Preferred Project Report

For:
Proposed Six Storey Commercial Building with
Two Storey Basement Car Park, Associated
Plant, Signage and Subdivision of Lot 8b

At:
8b Murray Rose Avenue,
Sydney Olympic Park

Application Number: MP10_0214

A01.00[02]

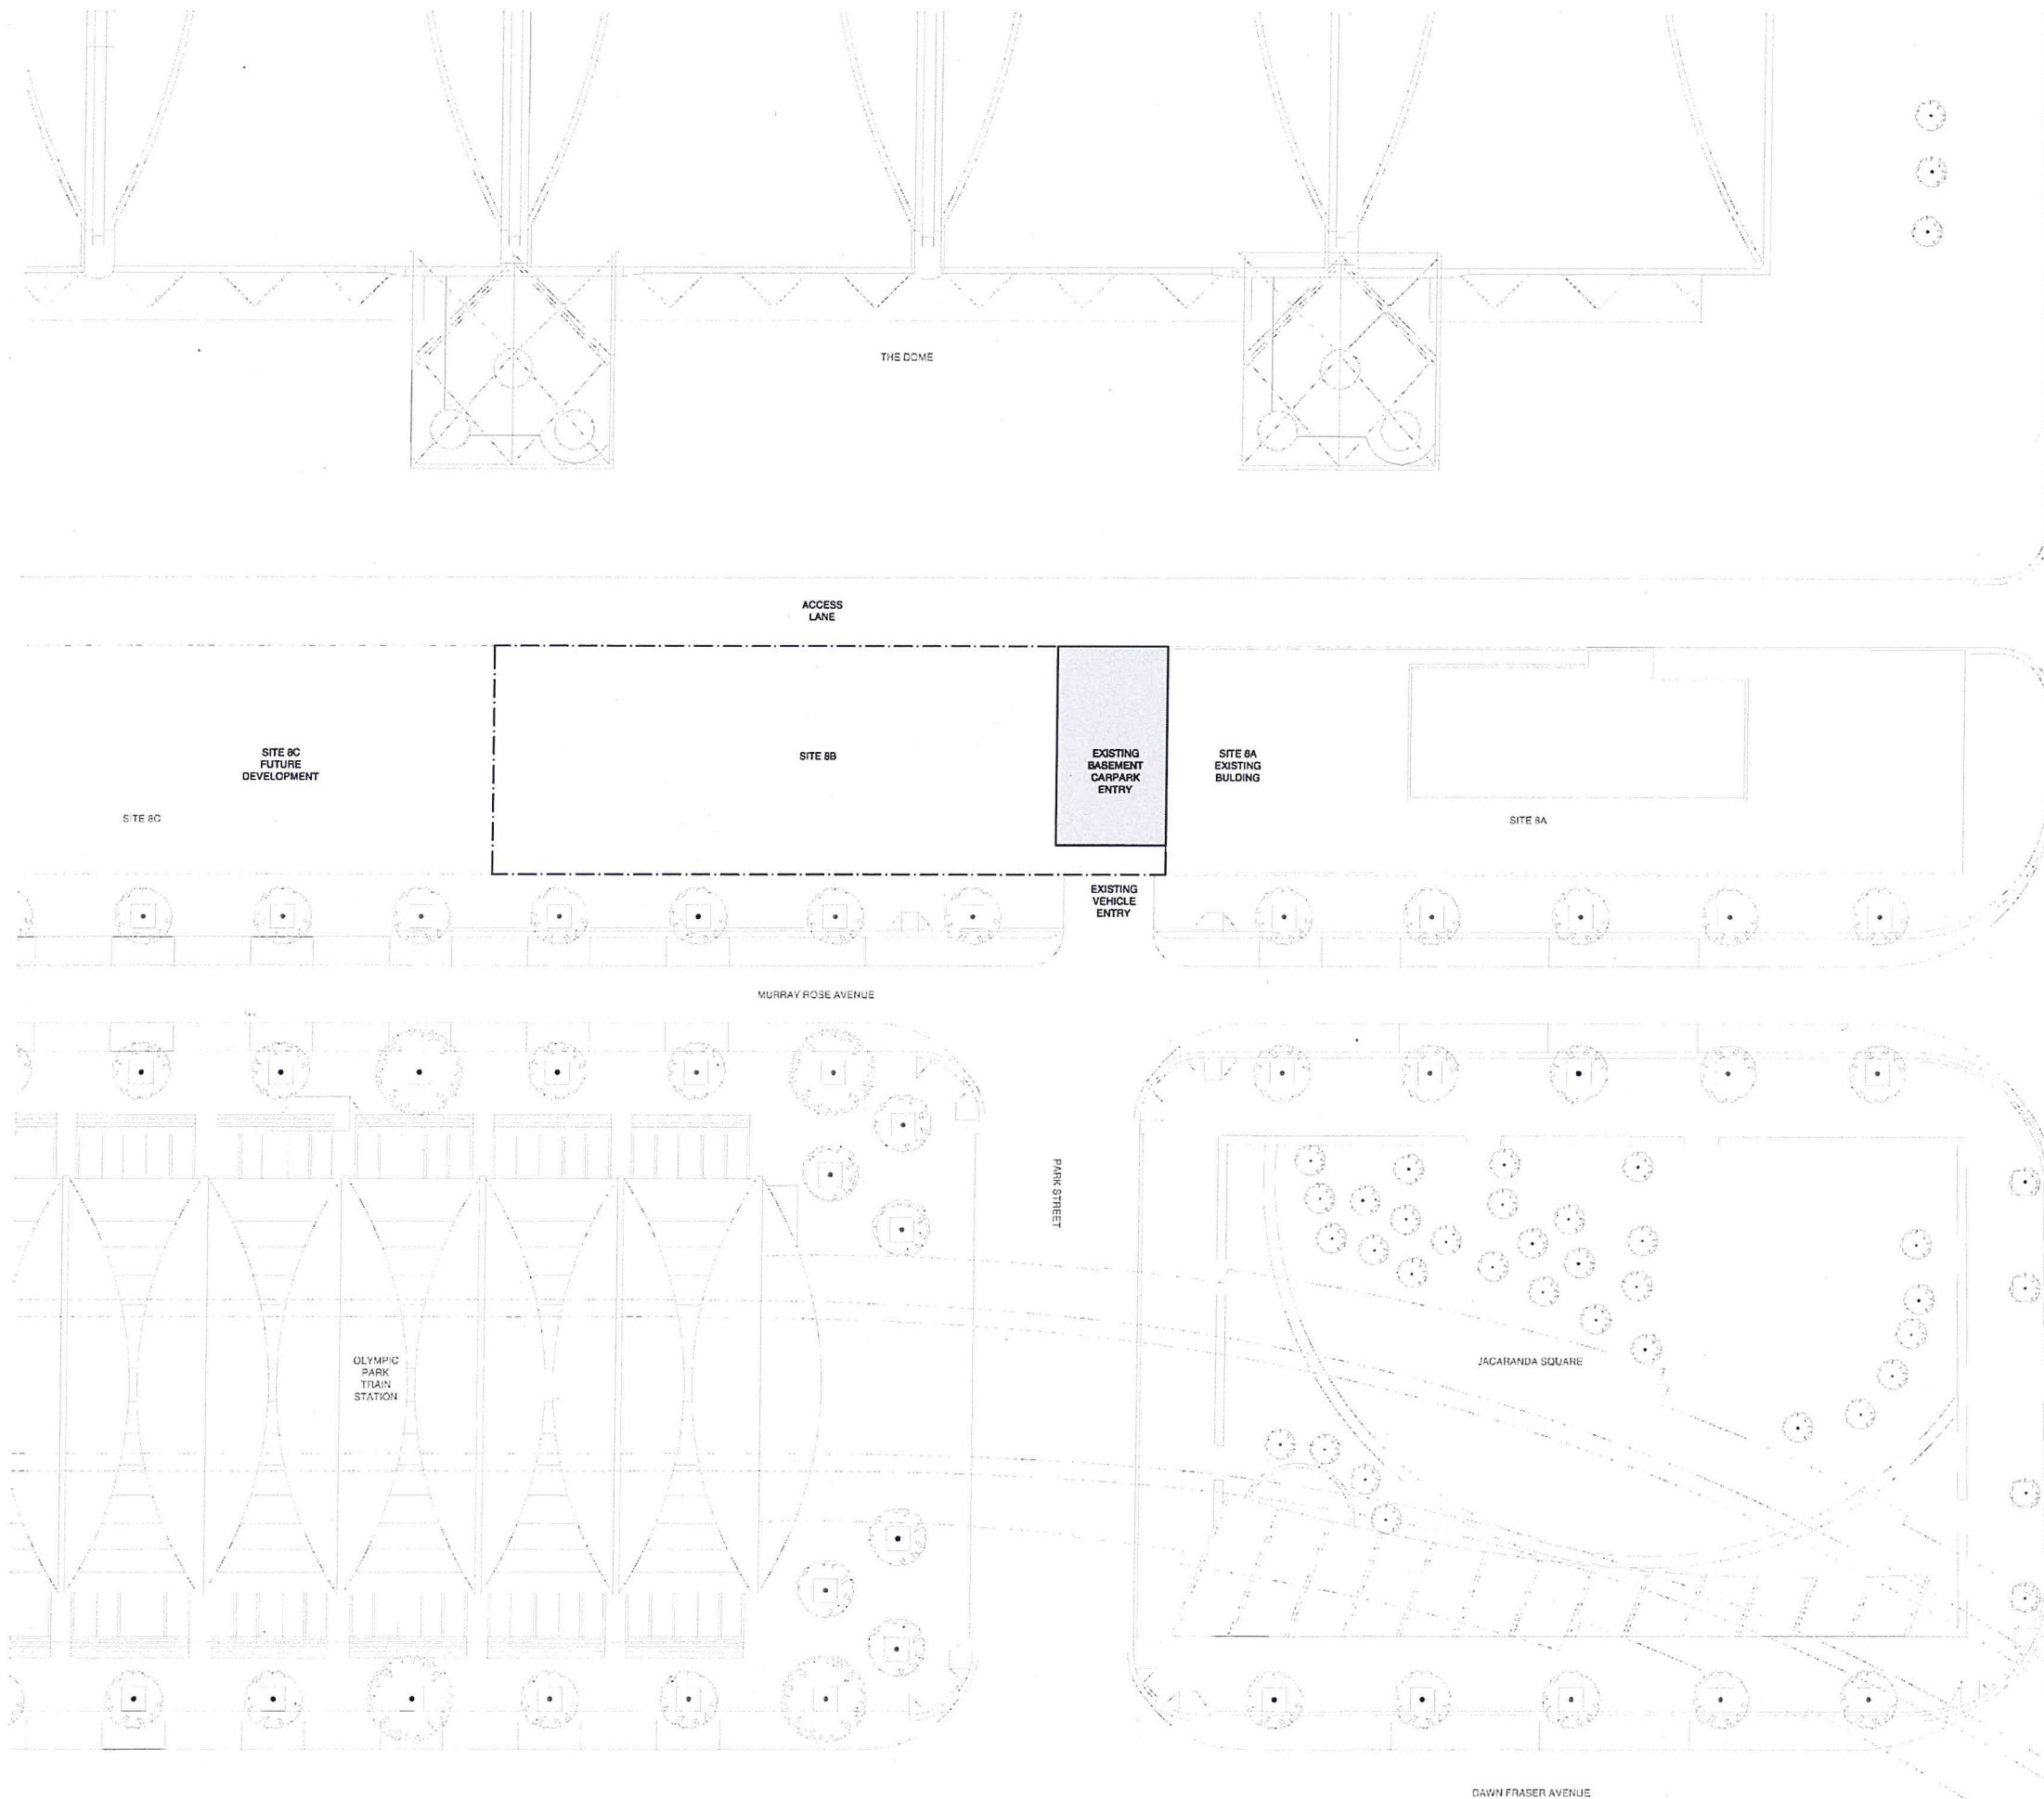
2.3 Public Domain A detailed Public Domain Interface Plan (PDIP), coordinating external treatments, levels, furniture, egress etc. for both frontages of the building, is yet to be provided. The PDIP (at minimum 1:200 scale) should provide details of all material & finishes, siting of street furniture, public lighting, access elements and any proposed commercial outdoor seating zones. The PDIP is to ensure coordinated finished footpath levels between Murray Rose Avenue and the proposed development.	Refer to the attached PDIP Drawing A01.10 [02]

A03.00[09]

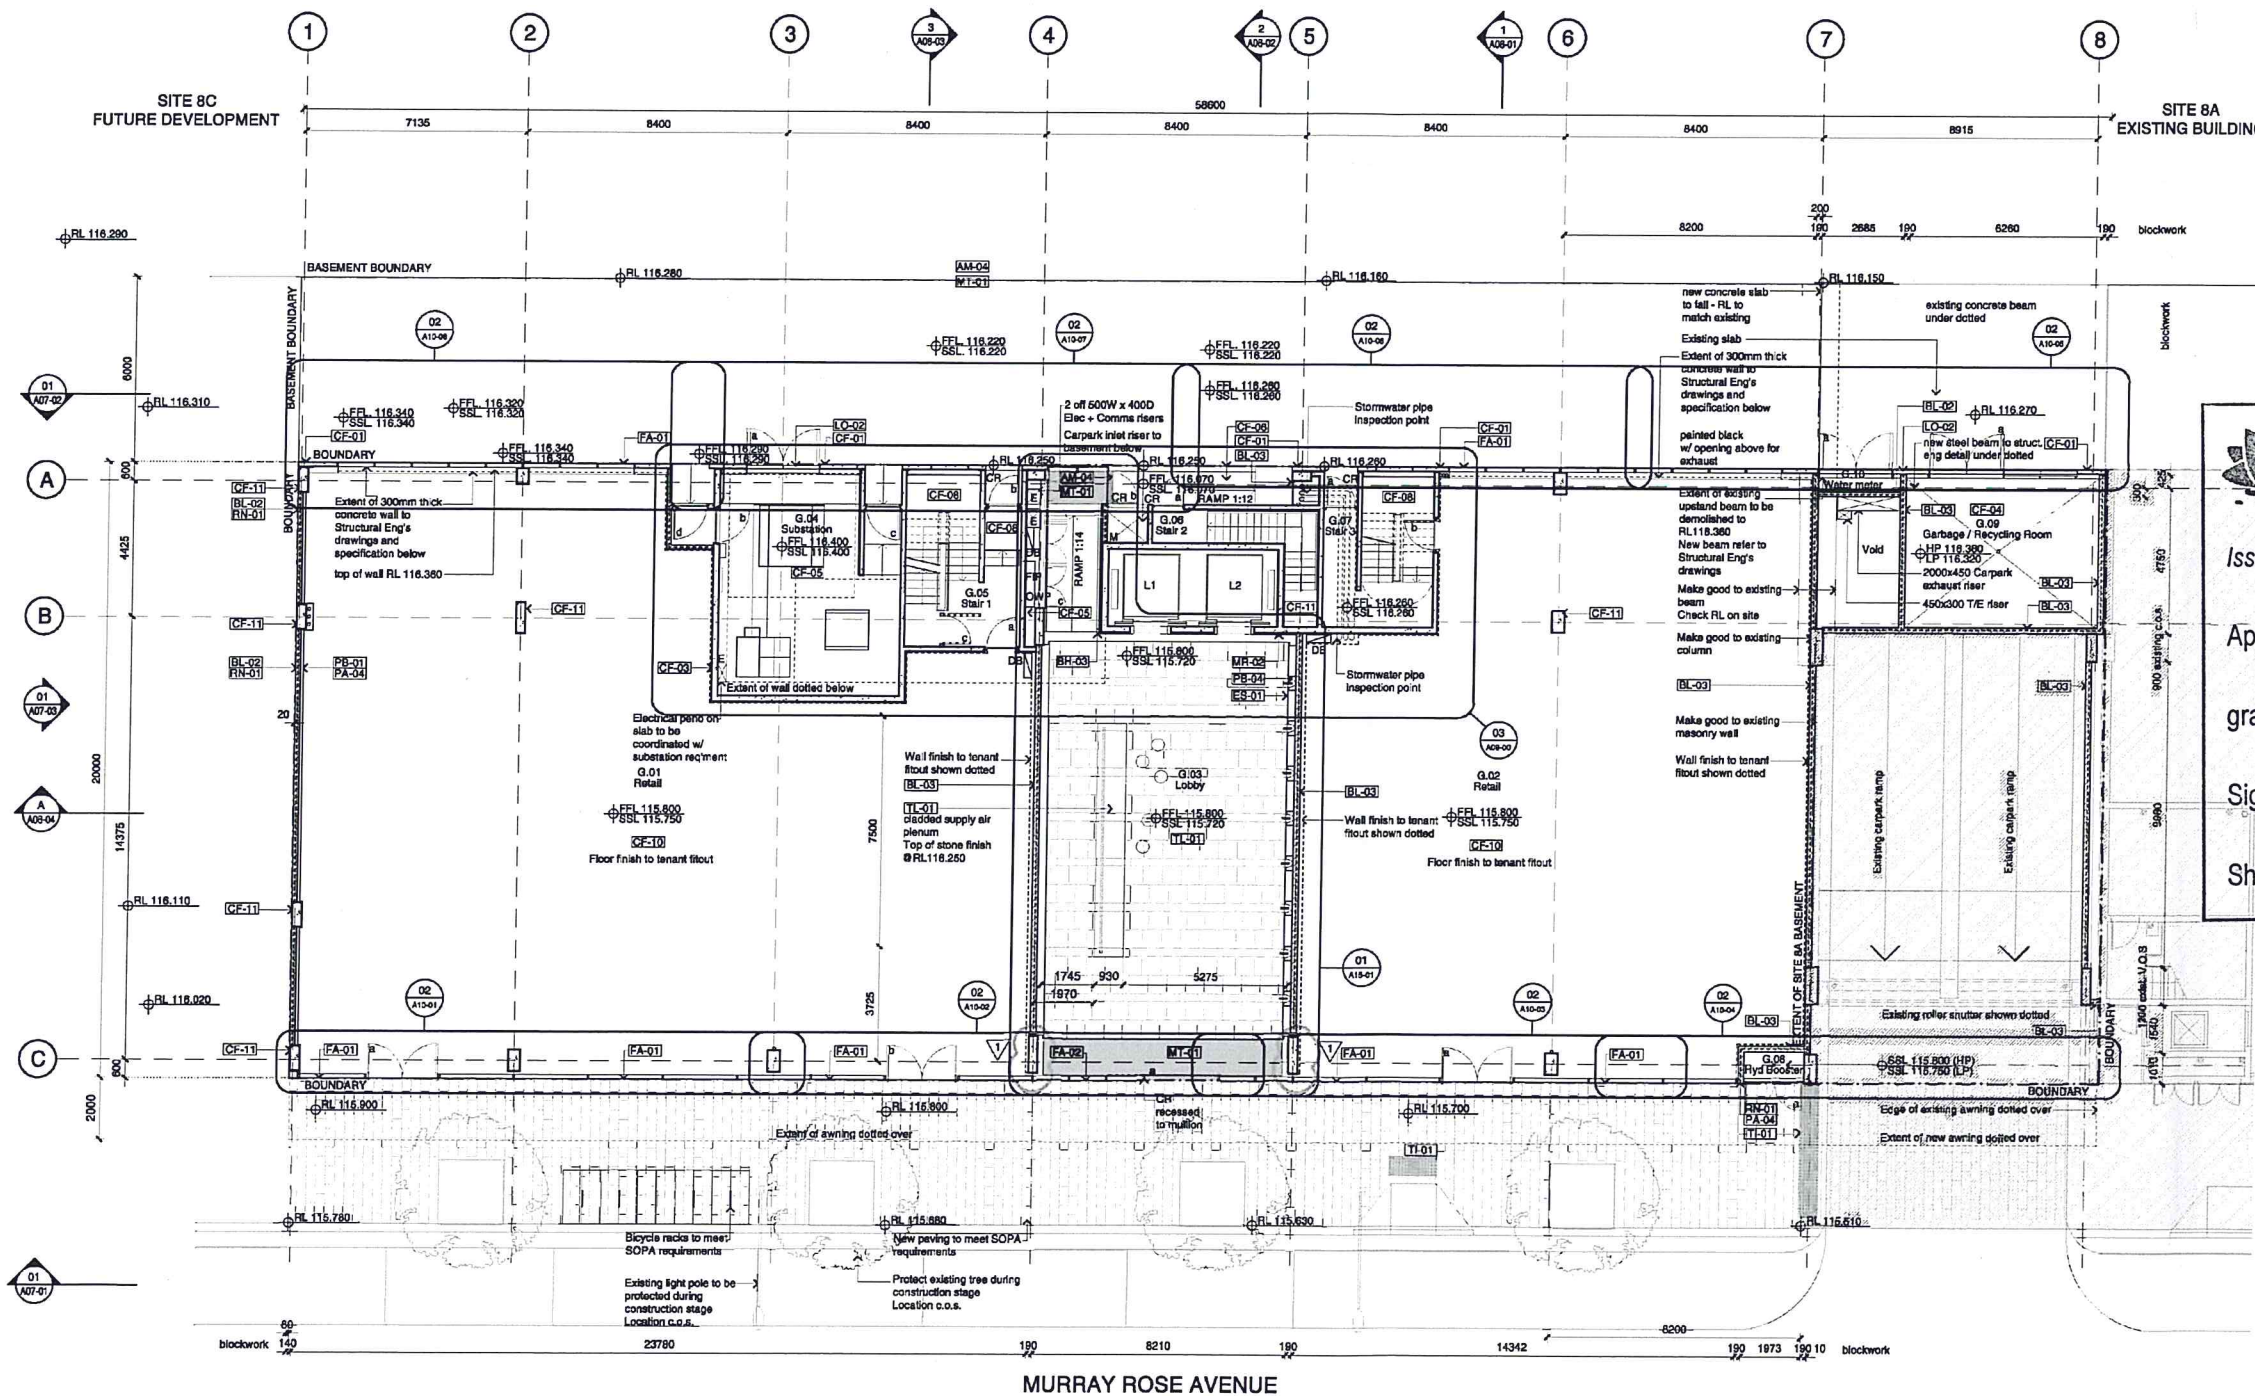
2.2 Design Issues Design Review Panel (DRP) The proposed amendments to the design to improve legibility of the building entry (Table 5.1 of the EA – SOPA DRP Comments, Issue 4, pg 38) have not been incorporated into the drawings. Relevant Drawings should be amended accordingly.	Please find attached Drawings A03.00[09], A07.01[04], A08.01[04] and A08.02[04] showing: ▪ Different façade system between Retail and Lobby noted as FA-01 for Retail and FA-02 for Lobby. These façade systems incorporate different type of glazing and different mullion spacing between Retail and Lobby. Clear toughened monolithic glass is used for the Retail whilst clear toughened laminated glass for the Lobby. Narrow mullion spacing to Lobby creates stronger entrance impact notwithstanding same glazing alignment in achieving the façade facing Murray Rose Avenue as one “skin”. It provides better and cleaner distinctive outcome compared to previous solution by recessing the face of glazing to the Lobby. ▪ Expressed laser cut lettering for building address ‘7 Murray Rose Avenue’ to face of awning. ▪ Clear glazed panel with frit in canopy above Lobby entry to enhance natural daylight onto FA-02 Lobby façade creating stronger building entry presence.

We note that the ground floor plan shows an	There is a change in level from the Murray Rose

SUBMISSION ISSUES	RESPONSE
RL of 116.35 on the access way, while in plan this level is shown at RL 115.8. The plans are inconsistent and it is not clear if the level of the access way is to be altered.	Avenue frontage (RL 115.8) to the rear lane (RL 116.25). Revised plans are annexed to this submission.

Ground Level Plan (Drawing A03.00 [09])

- Ramp and stairs have been removed from main foyer, providing level access from Murray Rose Avenue;
- Ramp relocated beside lift core and egress to the service land has been revised;
- Proposed substation room has been increased due to infrastructure requirements. This has resulted in a slight reduction in retail floor space;
